Hillingdon Flood Risk Assessment Addendum

Response to Consultee Comments

Subject	Client	Prepared by	Checked by	Issued
Hillingdon FRA Addendum	The Hillingdon Hospitals NHS Foundation Trust	Heather Wells	Matt Tandy	17 th November 2022

Figure 2- Site Phasing Plan (IBI Drawing reference THHR_01-IBI-XX-XX-DR-A-100007)

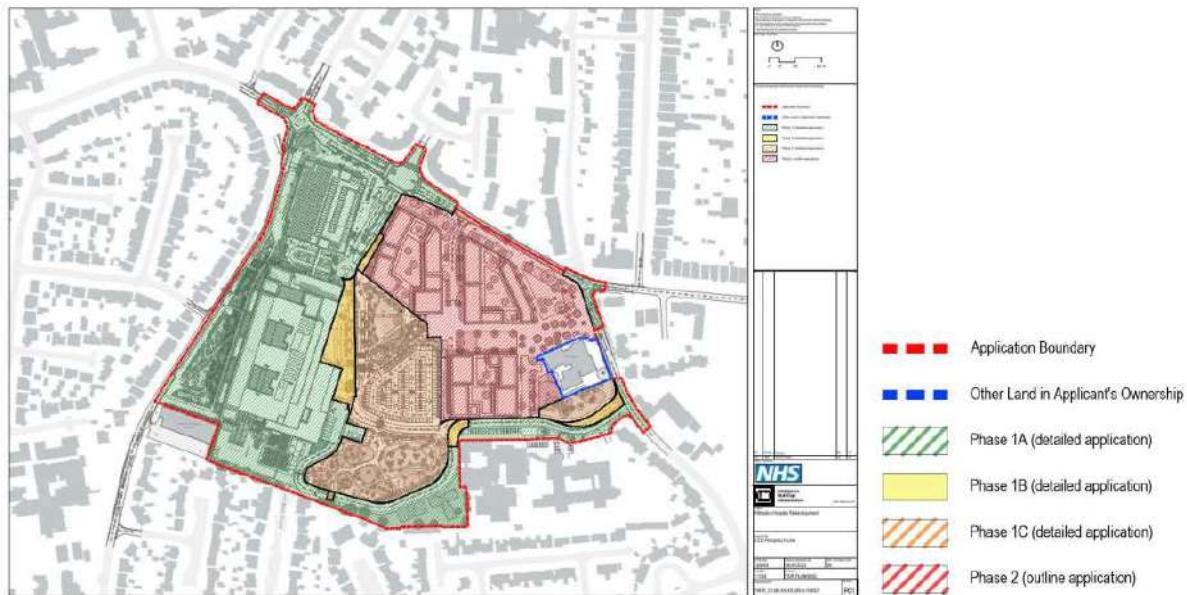
4. **Flood Risk Comment**– 'Clarification regarding the phasing of the flood relief culvert is required'

- **Response** – The Flood Relief Culvert proposed as part of the Phase 1c works. This must follow works associated with earlier phases as this mitigation is reliant on the proposed onsite fluvial flood basin designed to have a minimum volume of 1,955m³. Part of the existing hospital is required to be demolished in Phase 1c to allow for the construction of the on-site fluvial mitigation.

Figure 5- Proposed Surface Water Network Plan- Thames Water Discharge (AECOM Drawing Reference THHR_01-ACM-WS-XX-DR-C-772001)

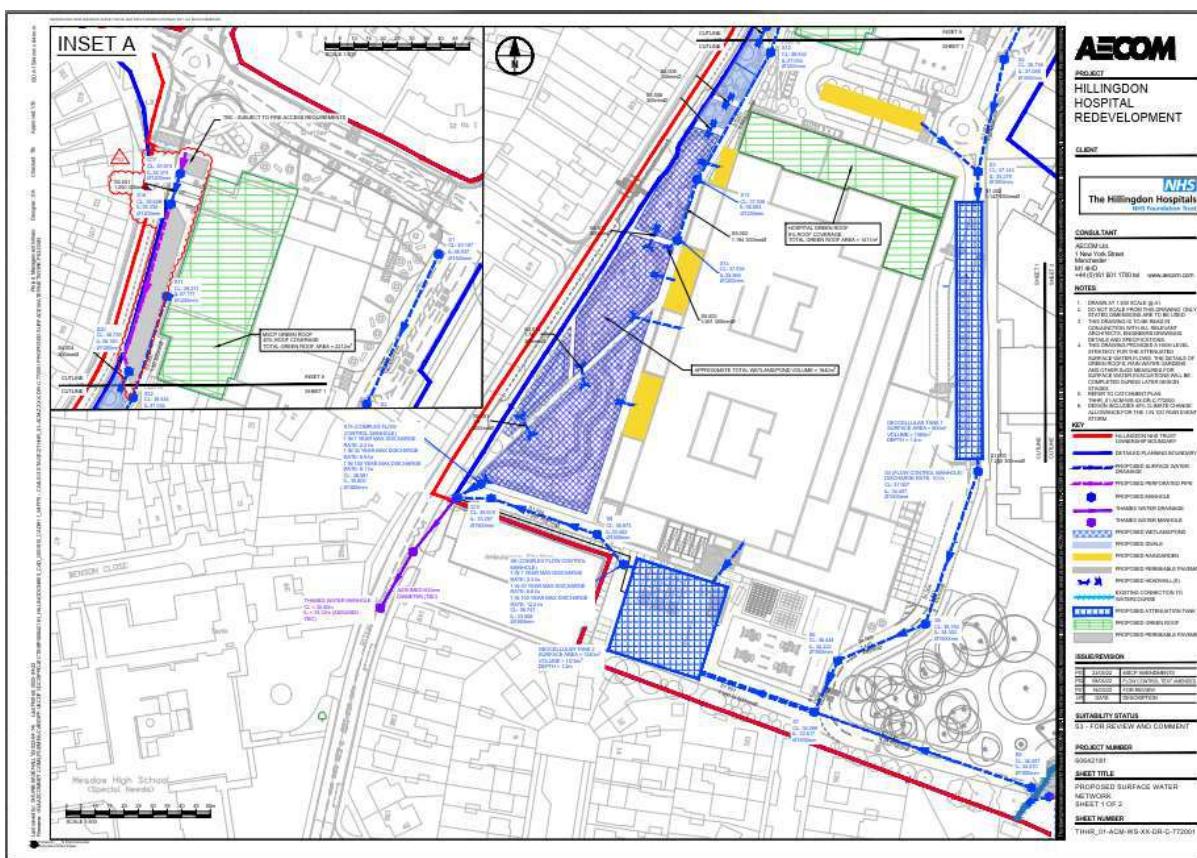
2. **Flood Risk Comment** – 'There is a lack of commentary in the flood risk assessment in relation to feasibility of SuDS that reflect the top of the drainage hierarchy i.e., natural attenuation, permeability of the ground and above ground storage areas'.

The western catchment of the site which includes the proposed hospital ward will discharge to an existing Thames Water (TW) Sewer Water pipe along Royal Lane. As such, this approach is understood to retain the existing connections to the TW sewer and minimises the discharge of surface water to the Ordinary Watercourse given the watercourse is sensitive to flooding.
